PLANNING CONSULTATION RESPONSE

Application No	2026/0480
Proposal	(AMENDED PLANS AND DESCRIPTION) Erection of a detached bungalow (Custom/Self-Build) and associated works including subdivision of residential garden; alterations to parking arrangements and retrospective changes to the external elevations of the host dwelling.
Address	66 Longley Street, Barugh Green, Barnsley, S75 1NT
Date of Consultation Reply	18/08/2026
Consultee	Katie Lawrence, Planning Ecologist

DRAWING TITLE
PROPOSED ELEVATIONS

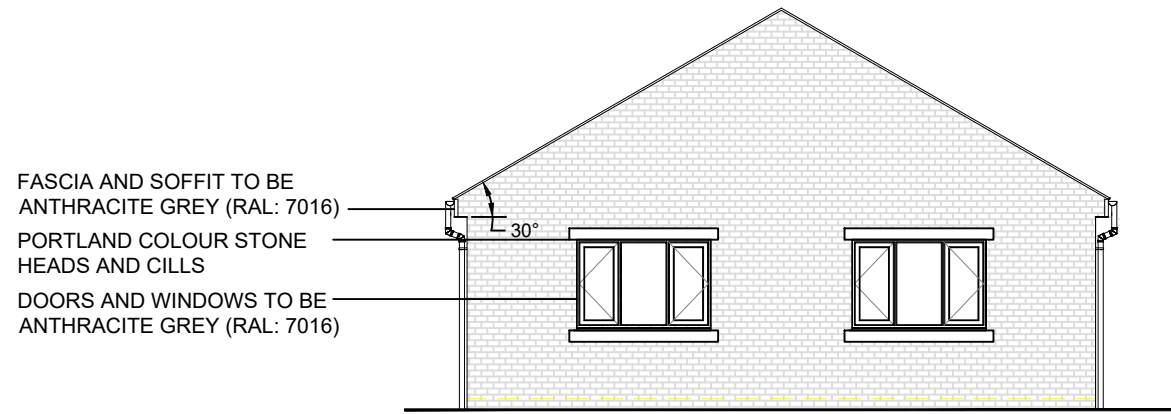
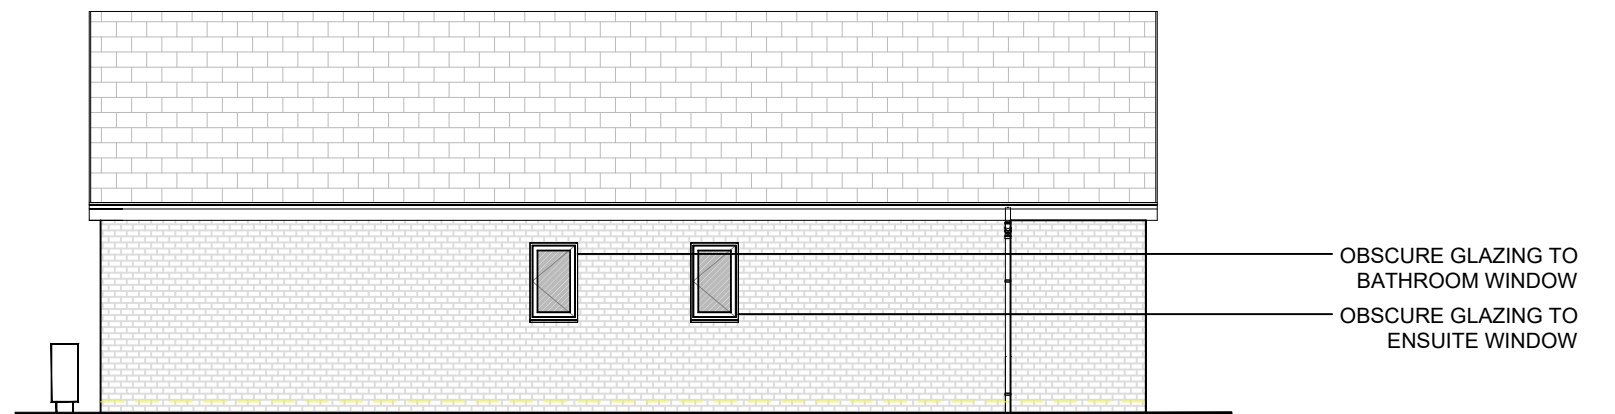
- As per the Biodiversity and Geodiversity SPD and NPPF the proposed dwelling should incorporate integral bat and bird boxes. This can be secured either by proposal plans being updated with suggested locations and types of the boxes indicated or by a planning condition, with suggested wording below.

Notwithstanding the submitted details, before above ground works commence a scheme for biodiversity enhancement, such as the incorporation of permanent bat roosting feature(s), and nesting opportunities for birds, shall be submitted to and agreed in writing with the Local Planning Authority. The approved details thereafter shall be implemented, retained and maintained for their designed purpose in accordance with the approved scheme.

A	EXISTING AND PROPOSED SEWERS SHOWN ON PLAN. ROOF HATCH UPDATED FOR PROPOSED PLOT.	29.07.26
REV	DESCRIPTION	DATE
DEVELOPMENT		
LAND ADJACENT TO 66 LONGLEY STREET, BARUGH GREEN		
DRAWING TITLE		
PROPOSED SITE LAYOUT		
DATE	25.04.26	SCALE 1:250@A3
DRAWN	WS	
DRAWING REF	LS-NB-PSL-01	REV A

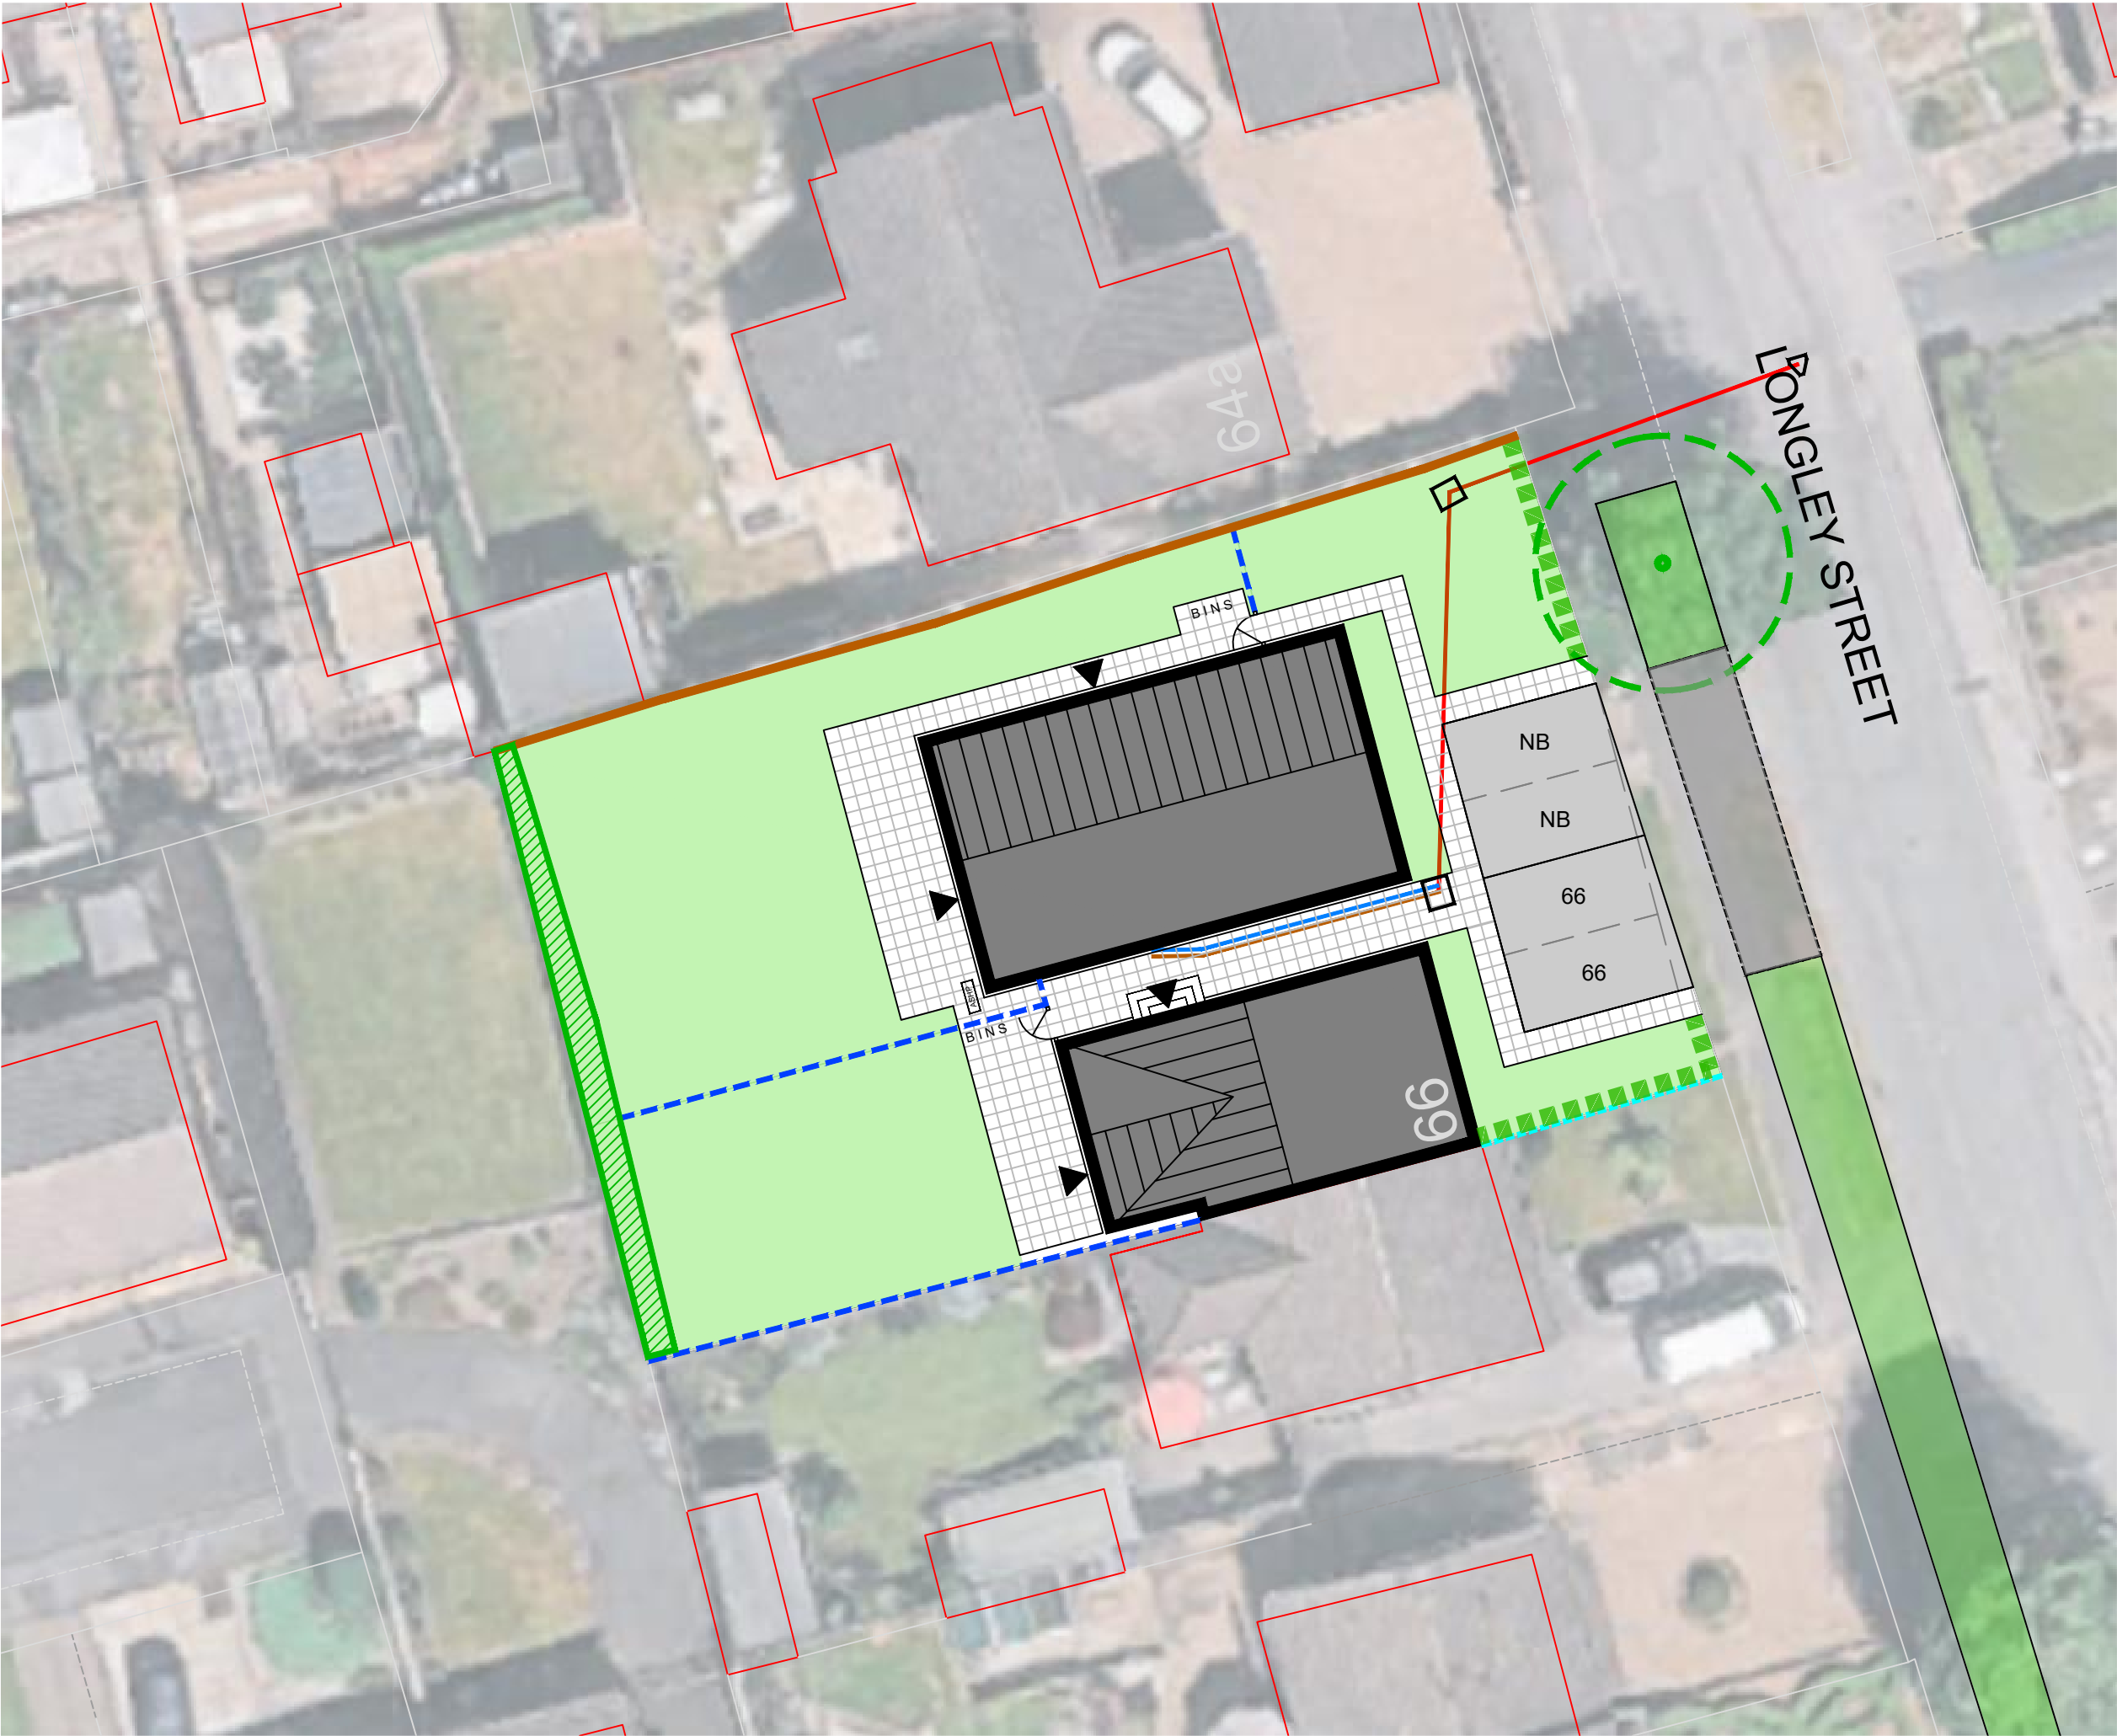
- When referring to the proposed site layout plan it appears as though shrubs within the current garden will be lost to the proposals and it is therefore suggested that an informative relating to nesting birds is included within the permission notice, if granted to ensure the legislation afforded to such species is adhered to.
